Ribble Valley Borough Council
Housing & Development Control

Application no: **3/2023/0546**

Address: **65 Mitton Road Whalley BB7 9RY**

Proposal: **Demolition of existing single-storey side and rear extensions, and construction of two-storey extension to the side and single-storey extension to the rear.**

Rev. B - Height of extension roof further reduced and white render finish indicated
planner request - P.E. - 08/09/2023

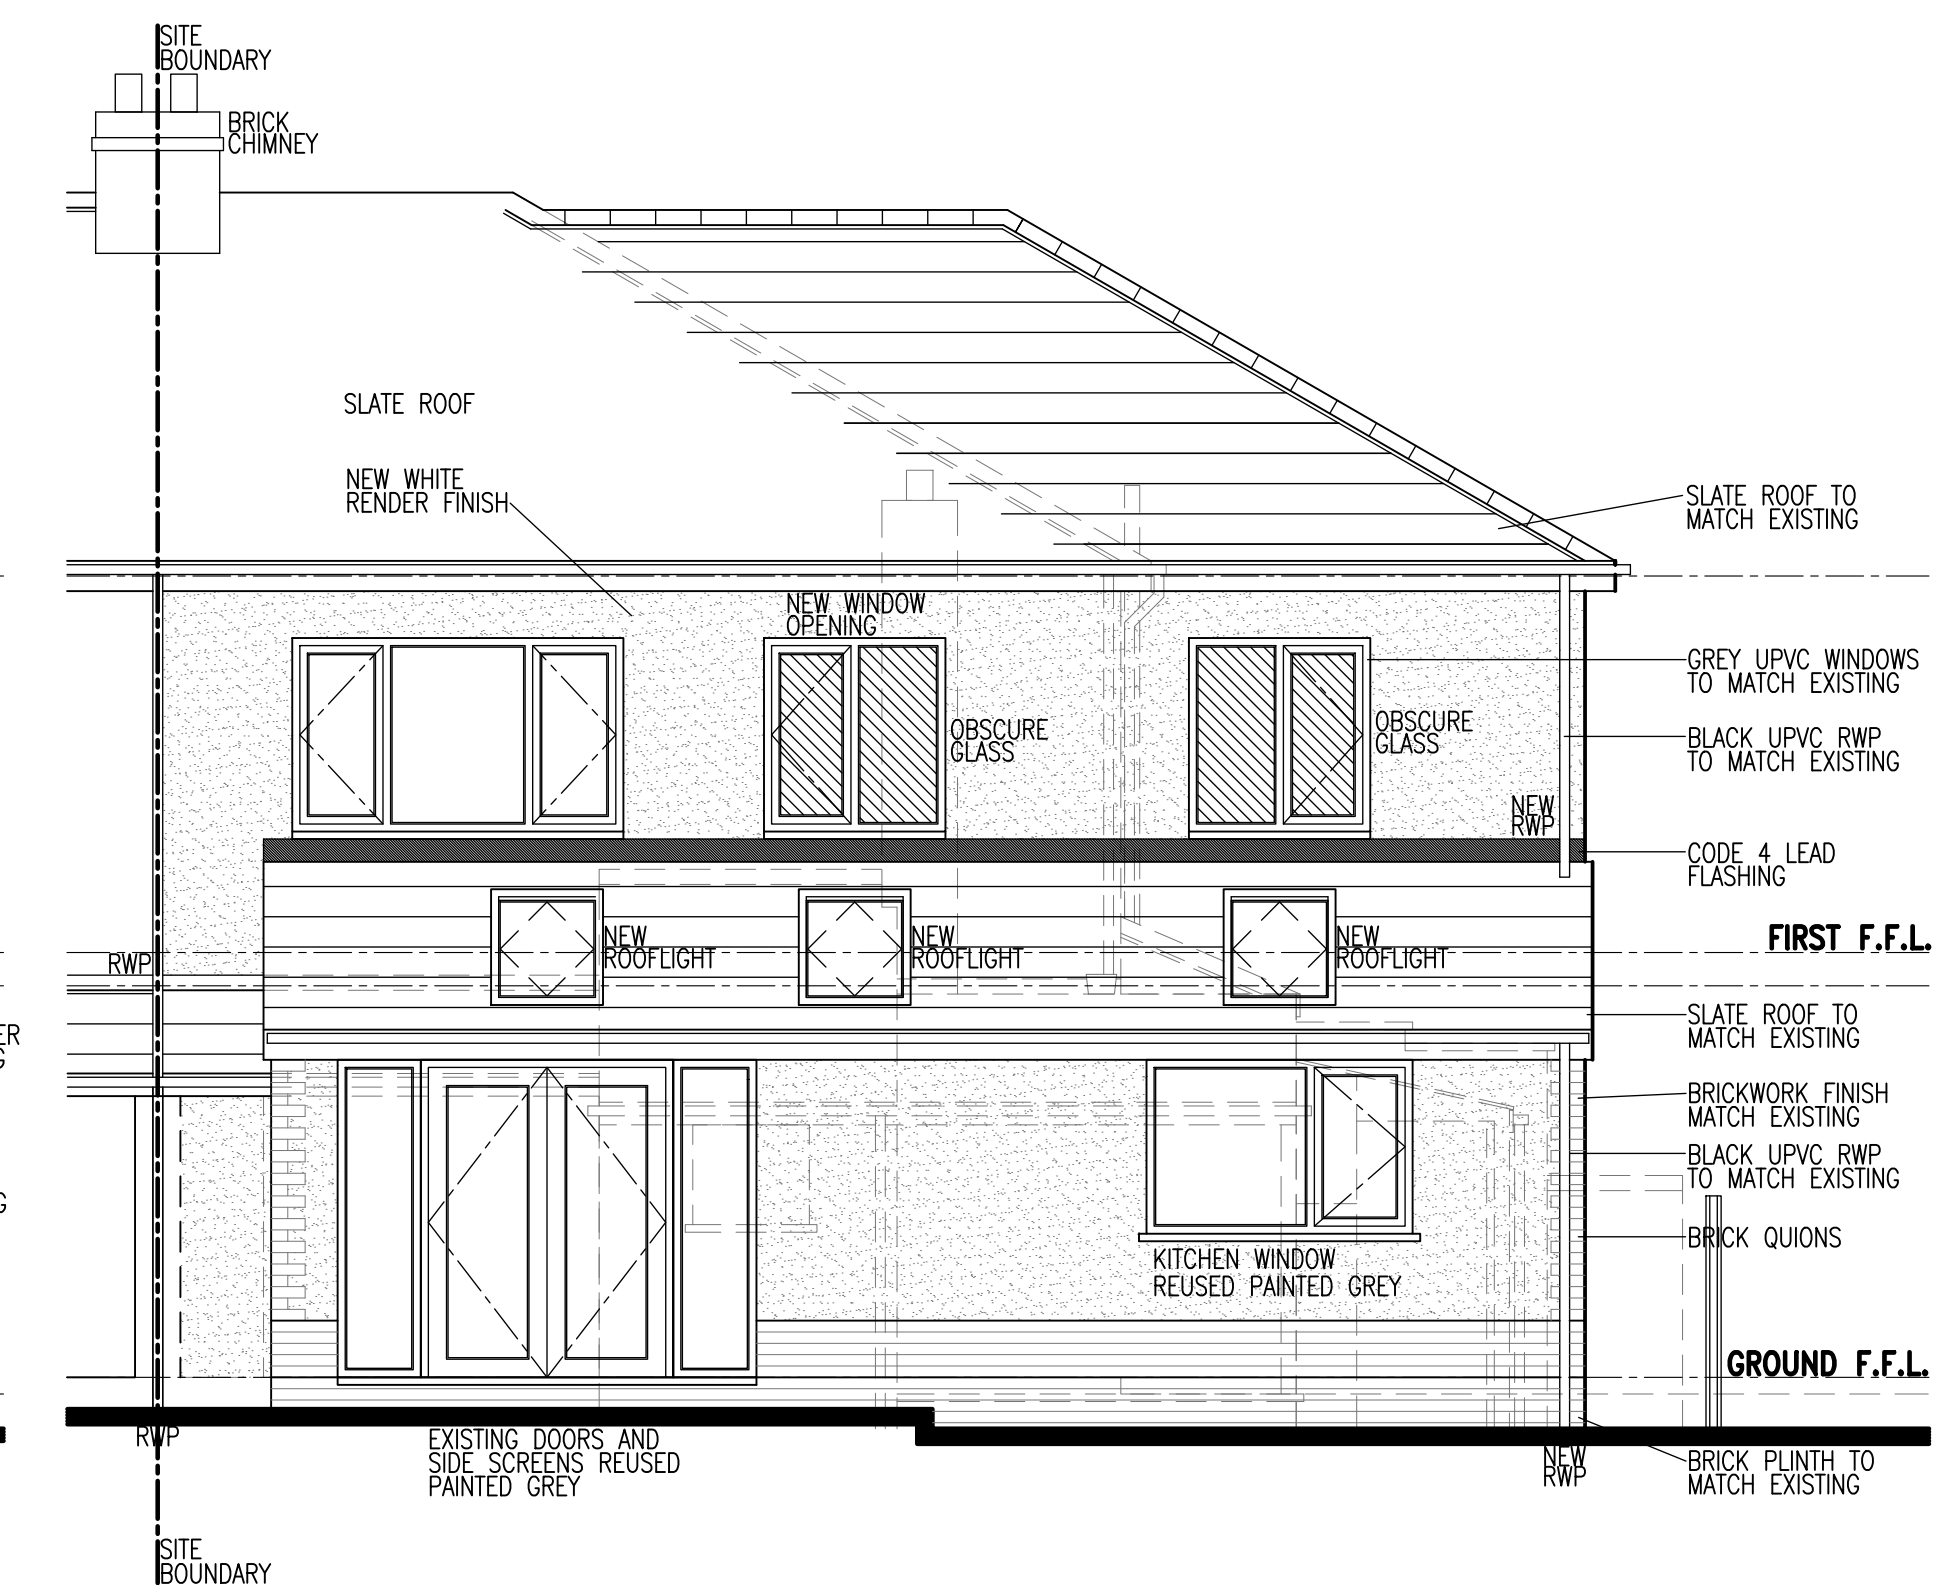
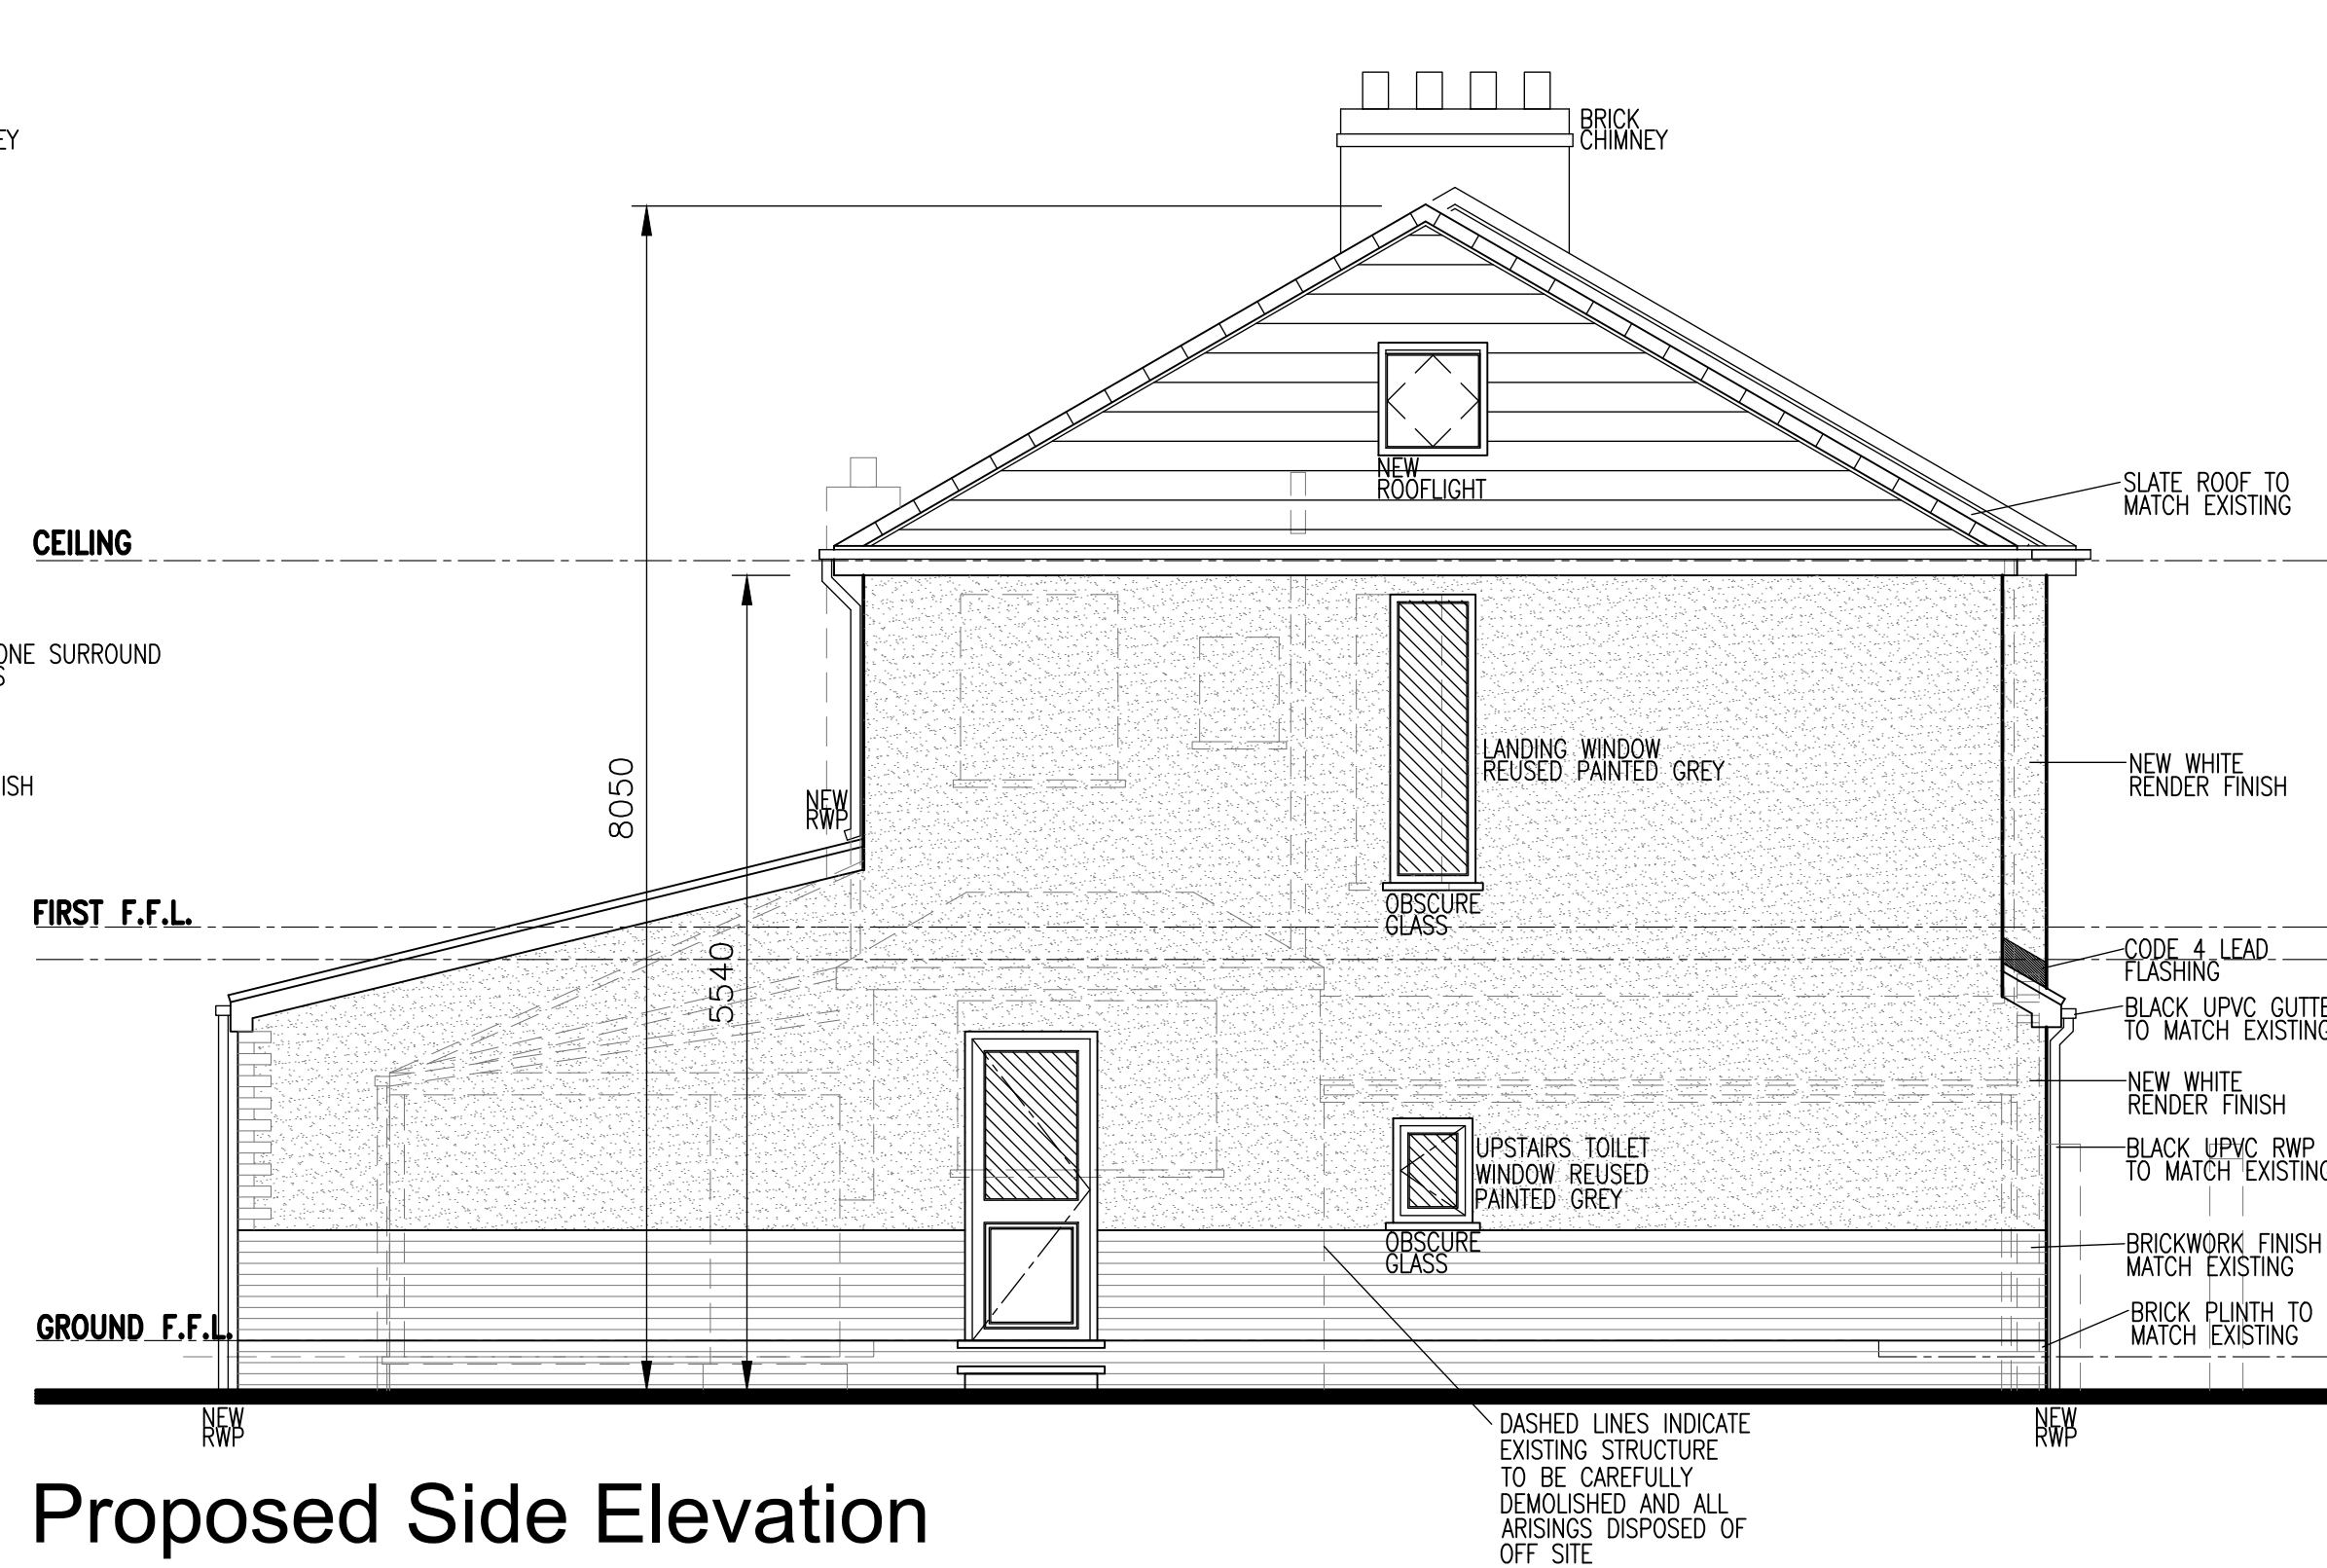
The LHA have reviewed drawing number Wilson/02 Rev A titled "Proposed Layouts" and are aware that the number of bedrooms at the dwelling will increase from 3 to 4. For the dwelling to comply with the LHAs parking guidance as defined in the Joint Lancashire Structure Plan, the LHA require the dwelling to provide 3 car parking spaces.

However, the LHA have reviewed the supporting documents and are aware that the dwelling can only provide one car parking space which fully complies with the LHAs guidance. This is because, while the LHA welcome the extension to the existing integral garage, with the internal dimensions being 2.7m wide by 6.2m in length, the garage still does not comply with the LHAs guidance when providing a car parking space. Therefore, there is a shortfall of two car parking spaces.

To ensure that the garage can provide a car parking space, the LHA require the internal dimensions of the garage to be widened to 3m and the existing access and driveway should also be extended by a further 2.4m to provide an additional car parking space and provide 3 spaces in total to comply with the LHAs guidance. These changes should be shown on an amended plan.
